Office of Environment & Heritage

Date: 18 March 2019
Your reference: SSI 9816
Our reference: DOC19/211089
Contact: Calvin Houlison
4224 4179

RE: Shoalhaven Hydro Expansion Project EIS – OEH Comments (SSI 9816)

APPENDIX 2: AREA WITH POTENTIAL ARCHAEOLOGICAL SENSITIVITY

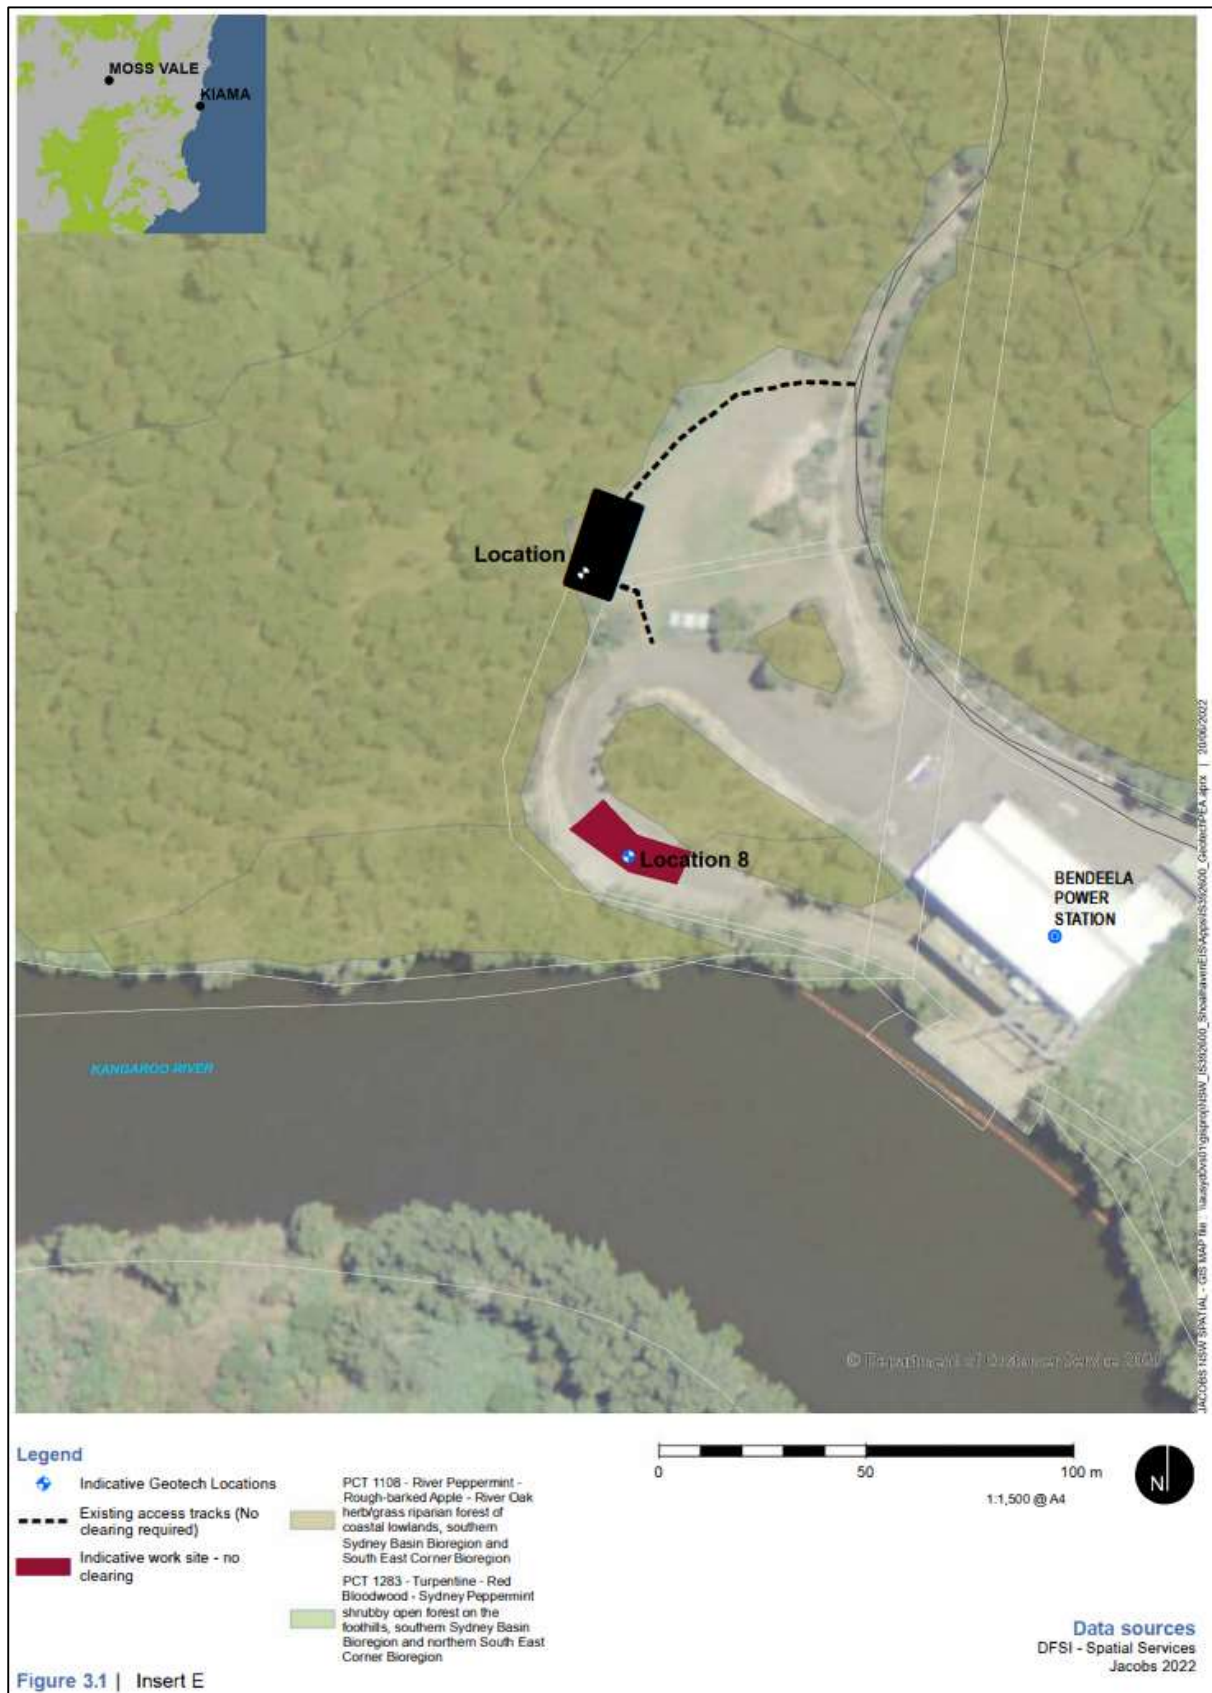
The due diligence assessment indicates that the location of boreholes 7 and 8 were moved to disturbed areas to avoid potential archaeological sensitivity. However, boreholes 7 and 8 are still located close to an area of potential archaeological sensitivity. As such, we recommend that management measures, such as temporary fencing, or inclusion of a "no-go" area as part of the recommended Aboriginal heritage induction for geotechnical contractors, are included to prevent inadvertent impact. The EIS notes that ancillary works areas are required. These ancillary works areas for borehole locations 7 and 8 could encroach on the archaeologically sensitive area if management measures are not included.
